Our Ref: PD/243912/03
Date: 19th September 2025
BWB Contact: David Hollingsworth
Mobile: [REDACTED]
Email: [REDACTED]

**PLANNING REF BE/150/22/OUT [BE/16/25/RES] – NEWLANDS ROAD, BOGNOR
REGIS P022 9NN– SURFACE WATER DRAINAGE**

This letter has been produced in response to the recent Lead Local Flood Authority (LLFA) objection letter dated 13th August 2025 and issued to Arun District Council as the latest consultation response on the above reserved matters submission. The LLFA have requested further information relating the location of surface flooding contained in the site during extreme rainfall events.

Drawing Title
Drainage Layout

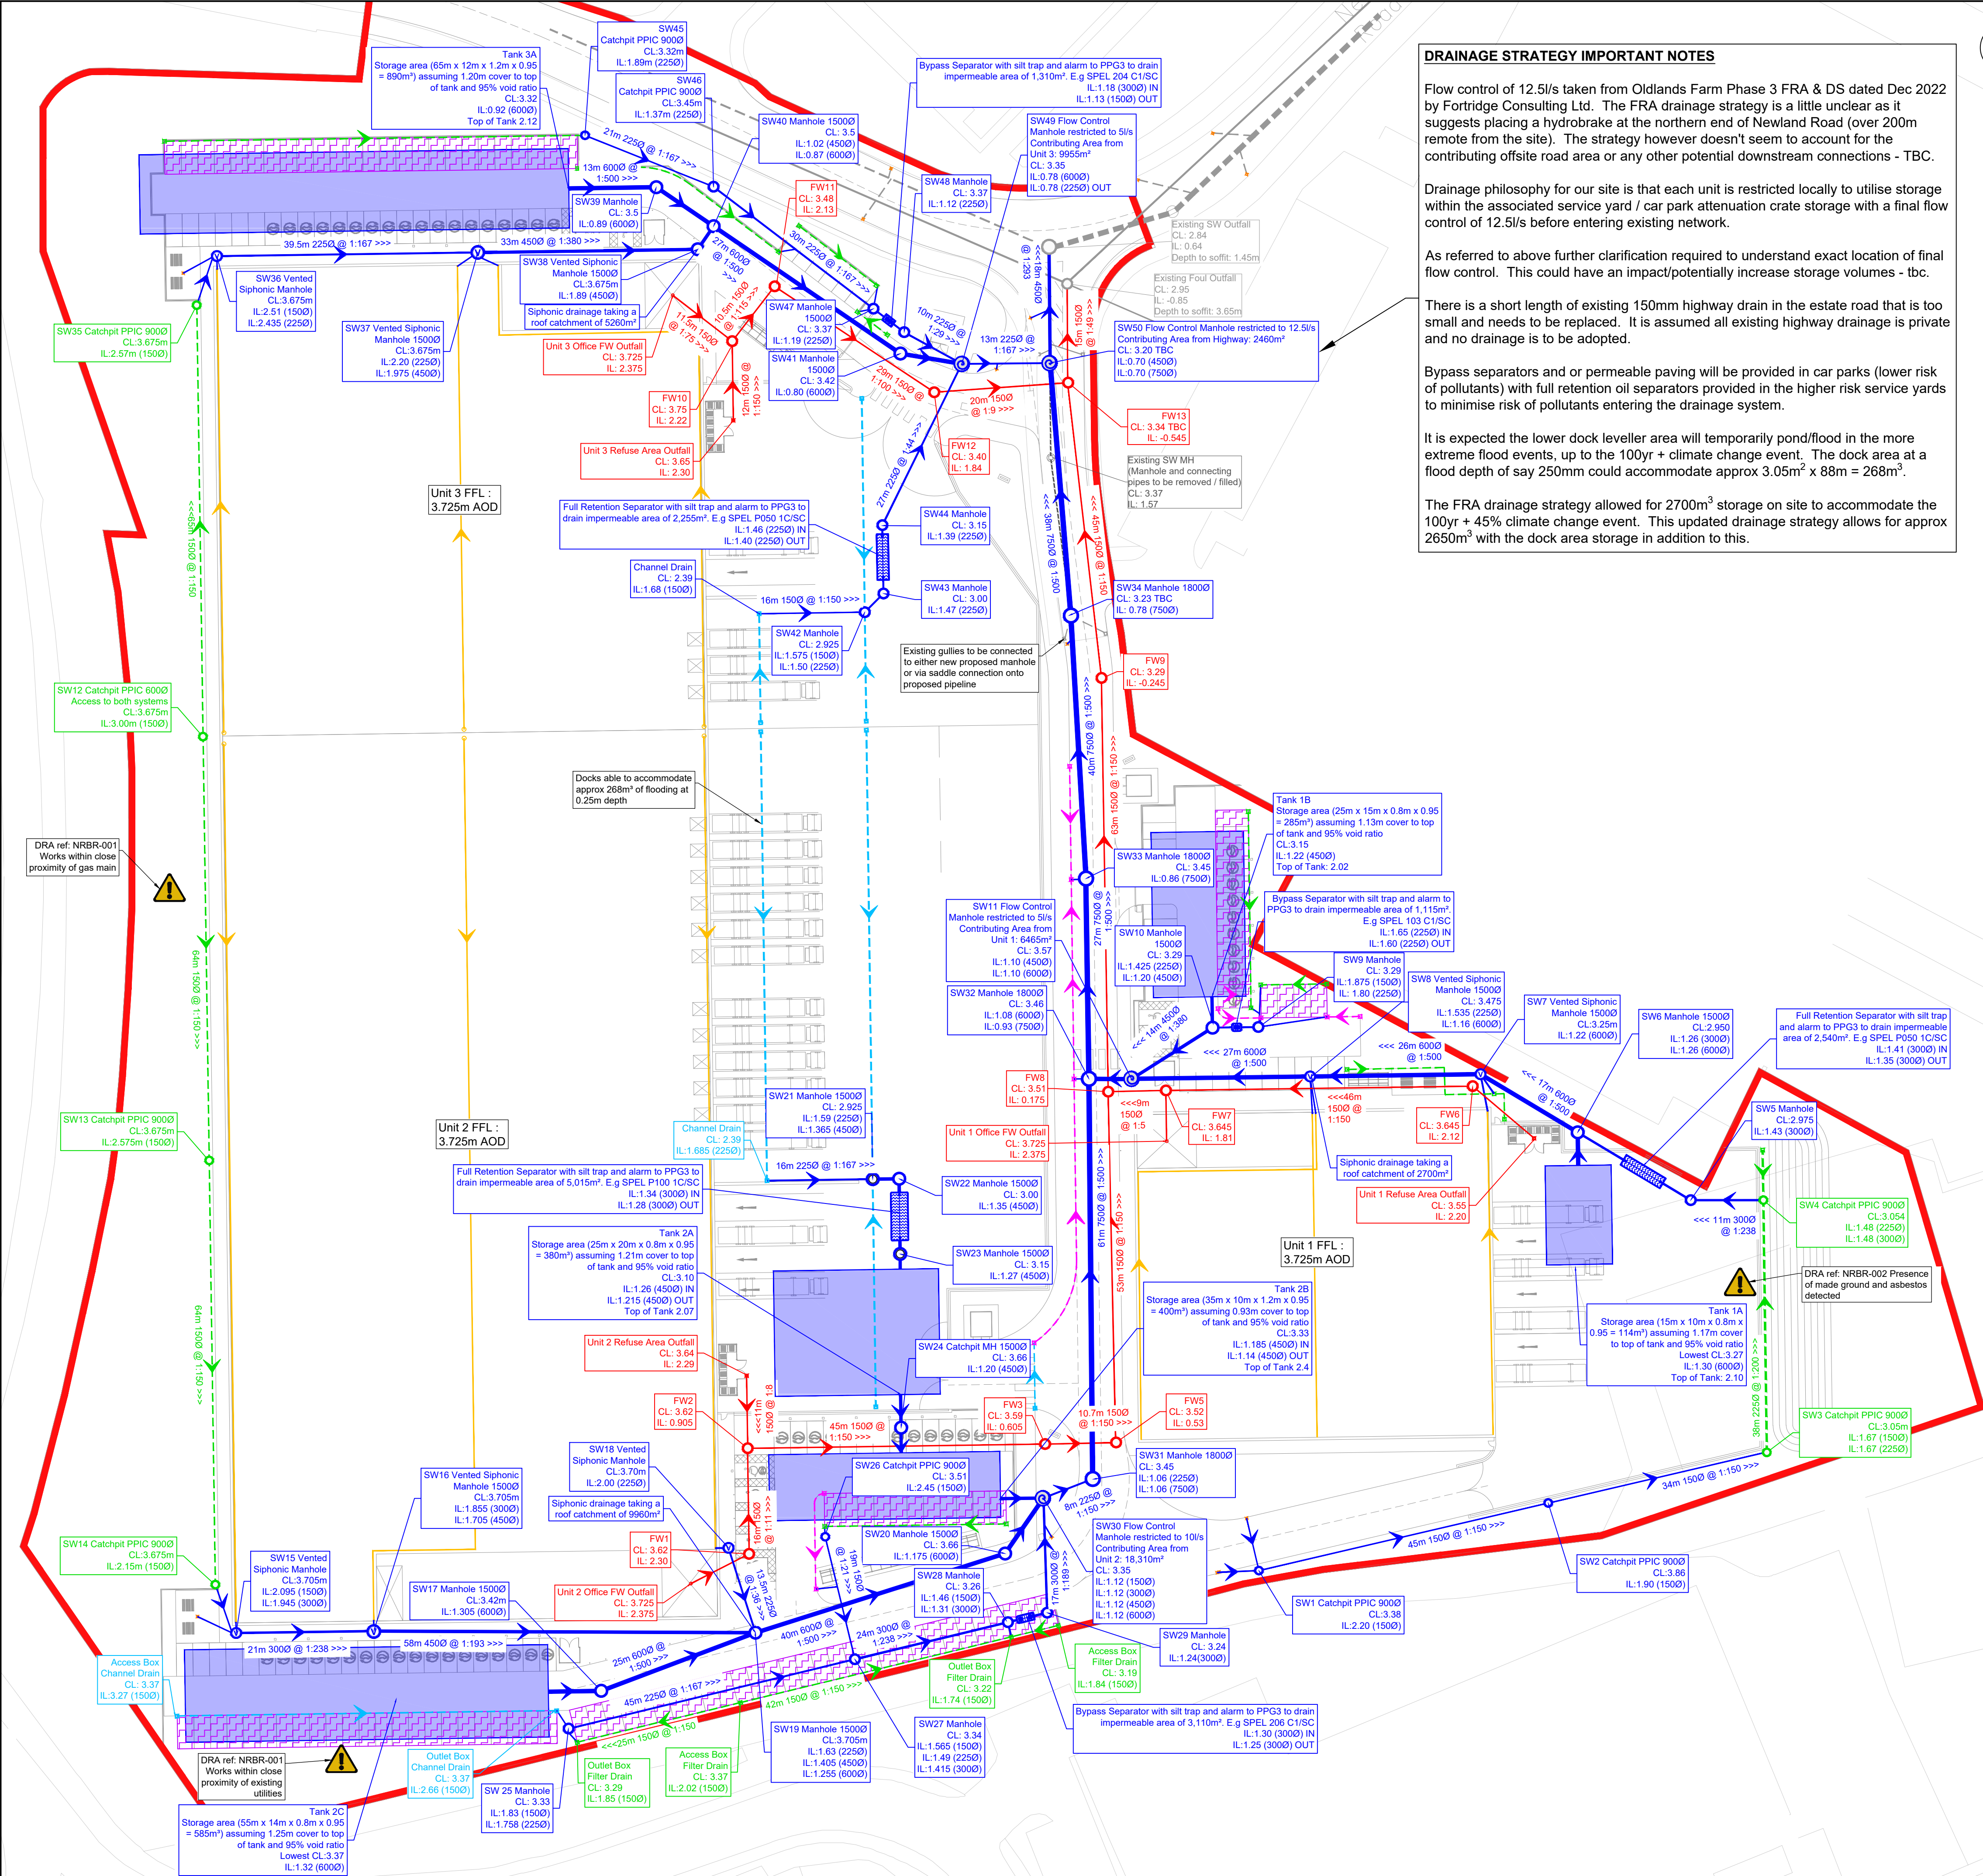
1. Whether the external flooding can be further reduced, and;
2. The LLFA have requested information to demonstrate that the building will not be flooded in the extreme rainfall events modelled (1% event adjusted by +45% for climate change) and that the surface flooding stays on site.

In answer to the first query we have further reviewed our proposals and incorporated a small amount of additional storage in pipe references 1.010 and 1.011. This has been achieved by upsizing 78m of previously 750mm diameter pipe to 1200mm diameter, introducing an additional 55m³ of storage into the system. This change serves to eliminate the minor flooding from manhole SW50 around the site entrance and reduces the spills from other manholes in the 100 year +45% climate change storm event.

Regarding the residual flooding in that extreme event, the additional of the extra storage and a number of other SUDS features eliminates most of the flooding except that in the low lying loading docks and a small spill from a manhole on the yard access to unit 1. We have consulted with the developer of the buildings and confirmed that the extent of external flooding proposed in the loading docks and the shallow flooding of the unit 1 yard access road is acceptable to them and is within the parameters of their development specification and within the operational expectations of building
